COMMUNITY SERVICES DEPARTMENT

April 27, 2022

Subject: Rolling Hills Ranch North Early Grading and Erosion Control Plan Review (EGP-22-002)

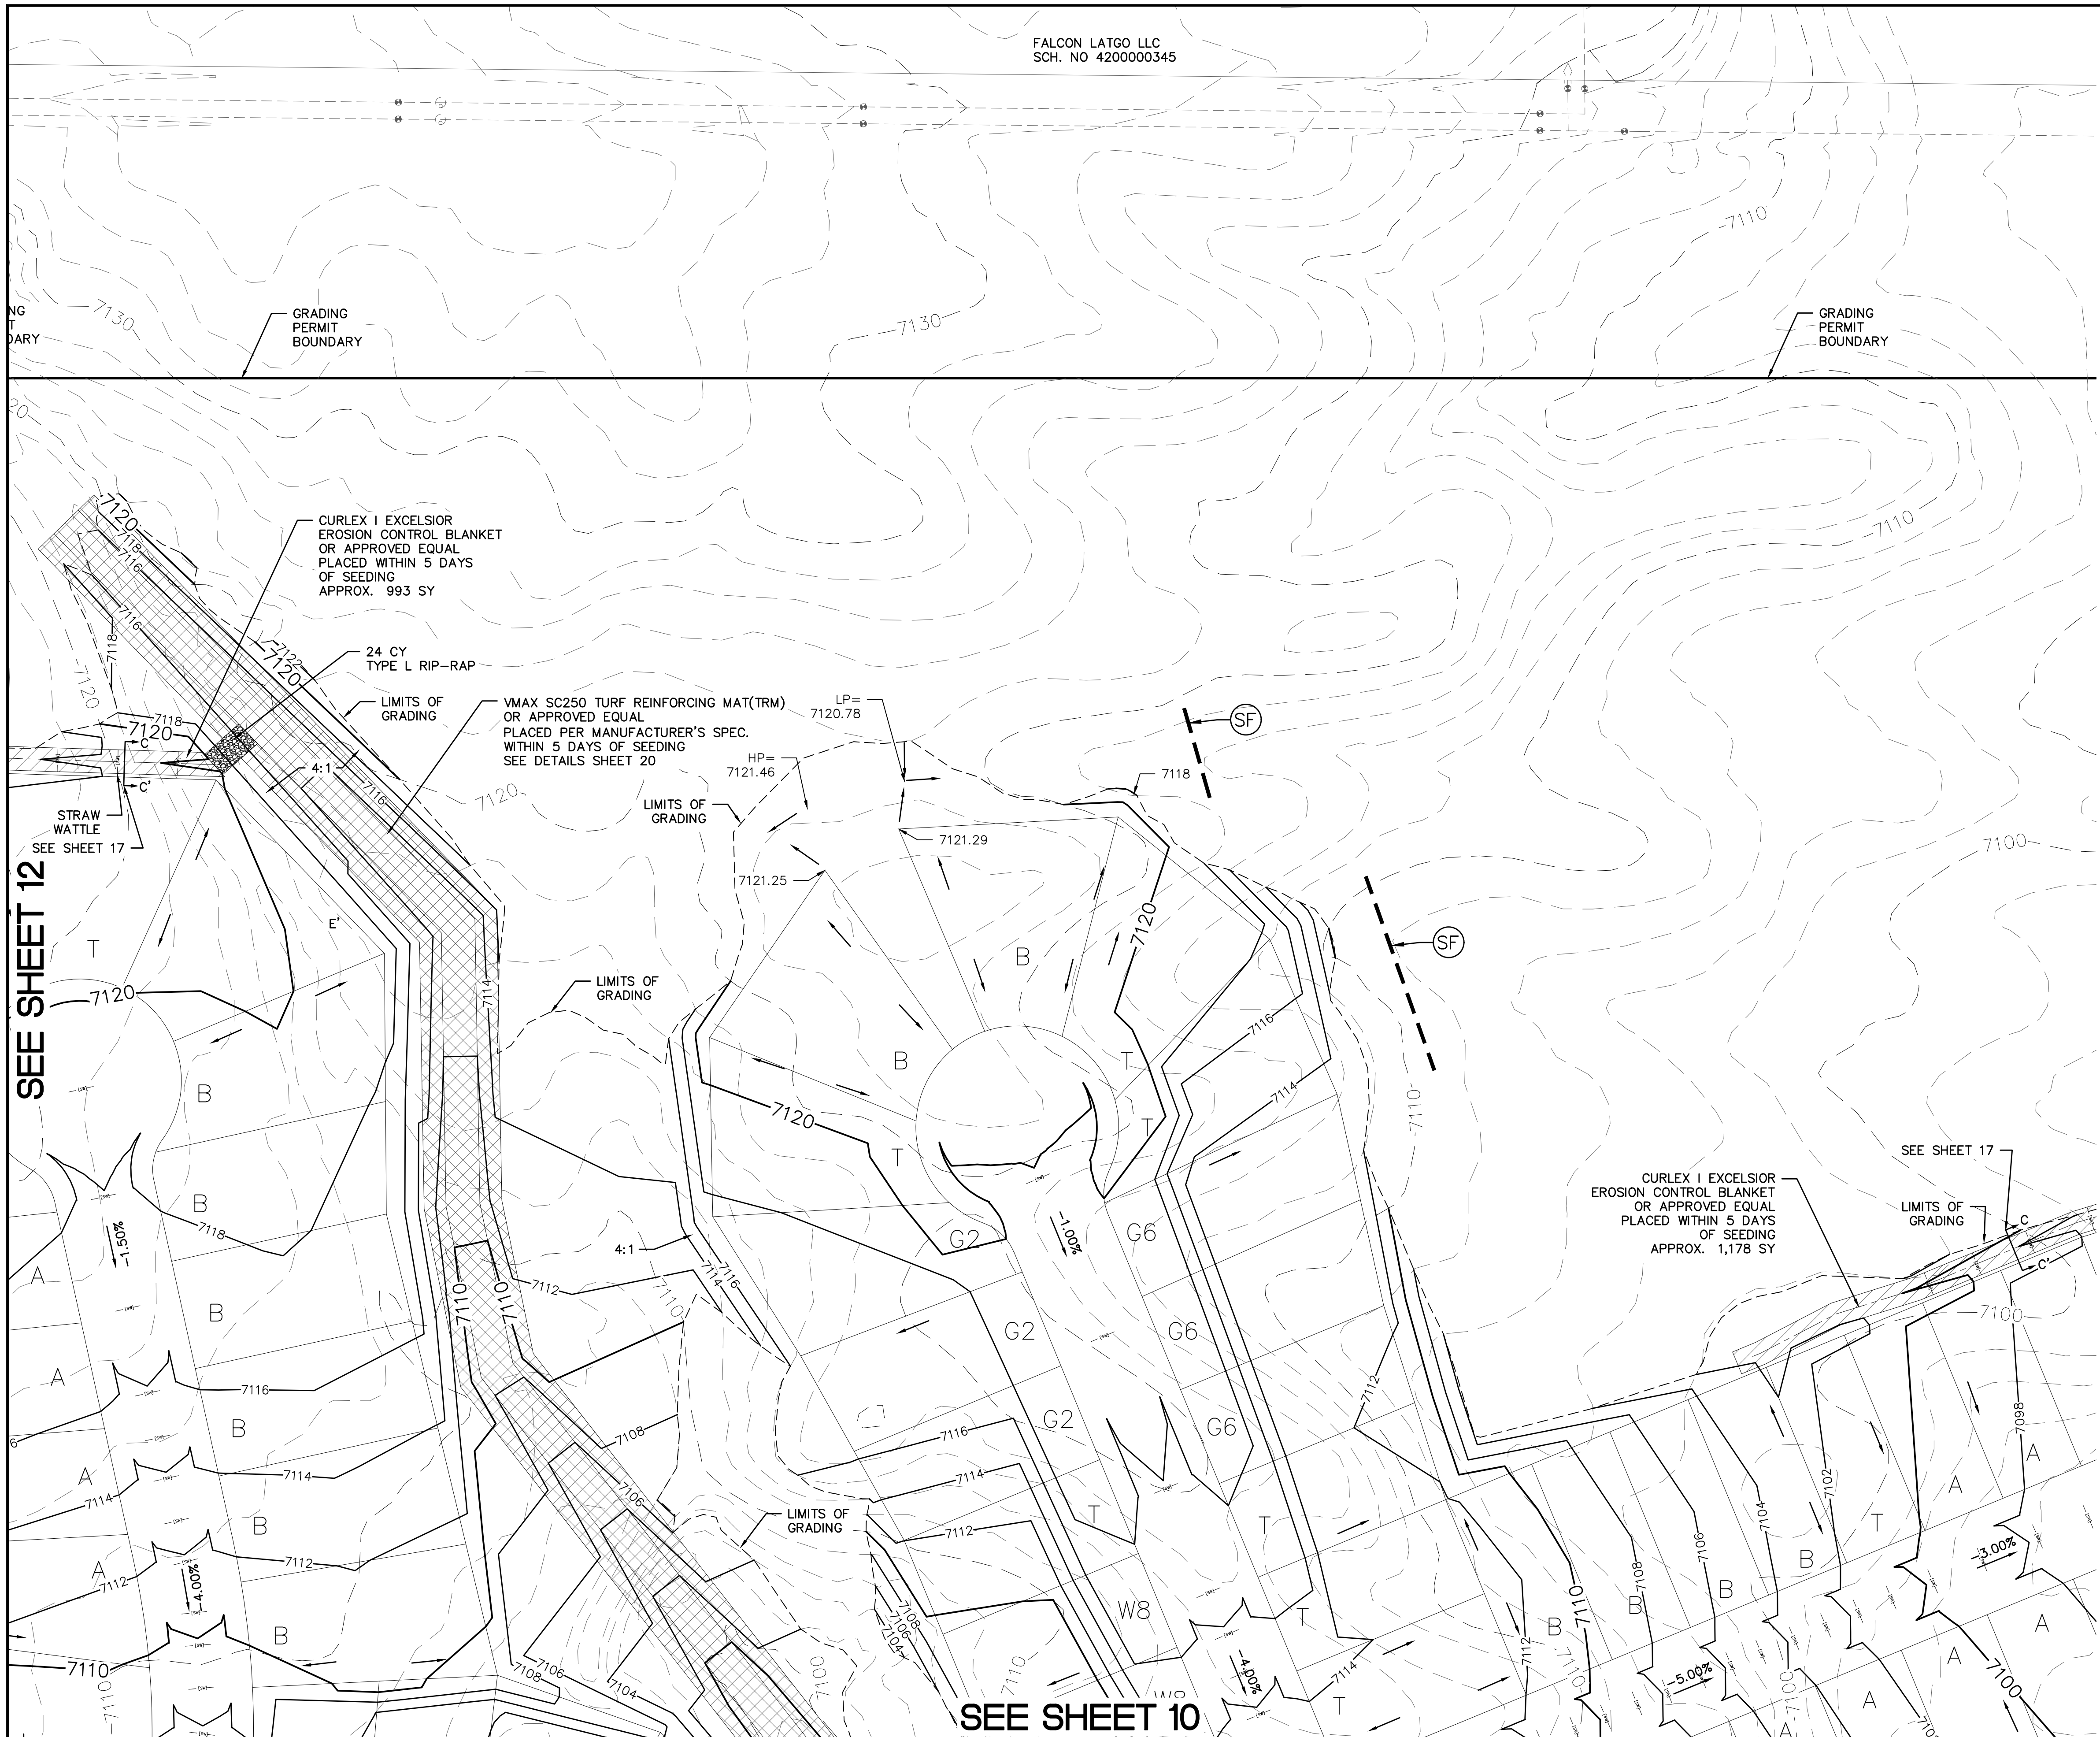
However, Sheets, 11, 13, and 14 of the Early Grading and Erosion Control Plans shows 25'-40' wide drainage channel being constructed along the northern boundary of the proposed residential lots of Rolling Hills Ranch North, within the bounds of 54-acre Hydrologic Element HG-13. This drainage facility channels overland runoff eastward then southward into an existing natural drainage channel in Falcon Regional Park. The plans do not show any stormwater detention facilities along the channel's path, and therefore it can be assumed that stormwater runoff will have a direct path into the natural drainage channel in Falcon Regional Park. This natural channel proceeds southeastward through the park's passive-use open space areas and will be routed under the proposed Rex Road extension, before exiting the park under Eastonville Road, east of the main parking area. Staff is concerned that this unimpeded drainage channel will allow for a higher discharge velocity and could greatly impact the natural drainage in the park, creating a higher risk for flooding and erosion in what has proven to be a sensitive environment that does not respond well to extreme stormwater runoff events. Staff requests the applicant demonstrate that flows from this drainage channel will not negatively impact the natural or recreational values of the park.

Furthermore, while the 40' Drainage and Grading Easement allows for the construction of drainage facilities within its bounds, the aforementioned drainage channel does extend beyond the easement boundary and into Falcon Regional Park by an estimated 50 feet. The proposed drainage channel should be removed from County Property and located on the applicant's property as there is no documented easement providing for infrastructure within the park outside of the already provided drainage and grading easement.
